Application for a Non-Material Amendment Following a Grant of Planning Permission

First floor front extension

23/03122/HOUSE

SM436.3 REV A

Flank elevation

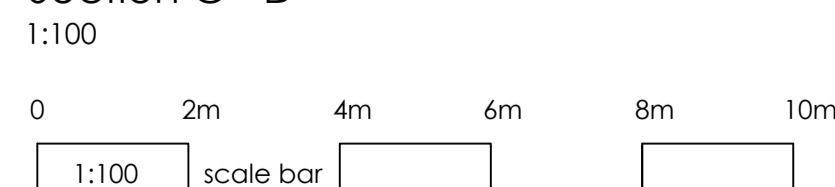
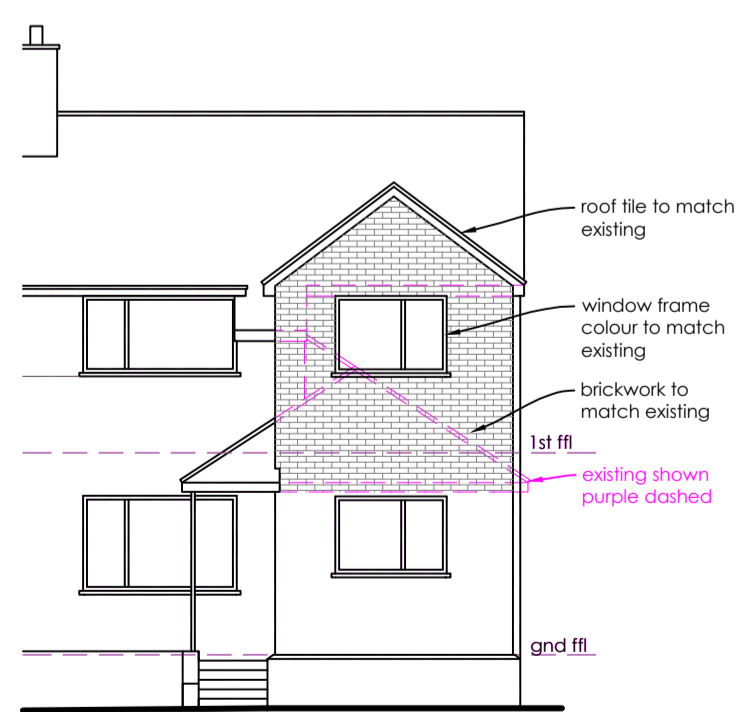
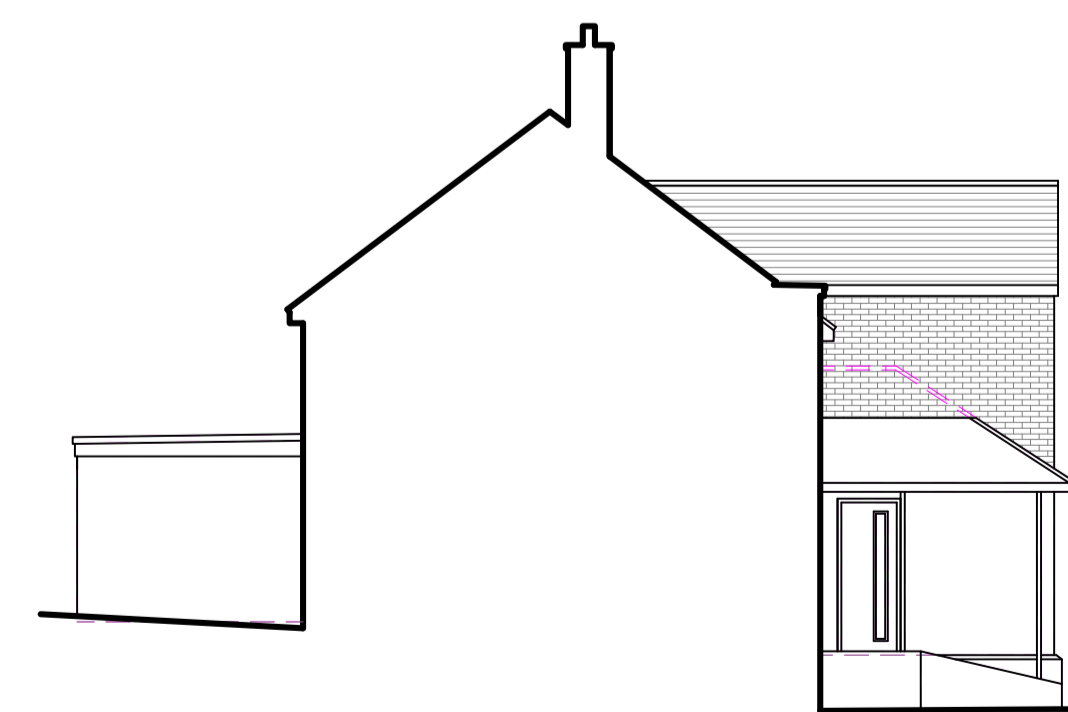
There was a discrepancy between the flank and front elevation roofs.

The front roof shows a gable, where the flanks roofs show a hip.

The delegated report clearly expects the roof design to be a gable and to match the attached neighbour's roof.

All elevations now show the gable roof.
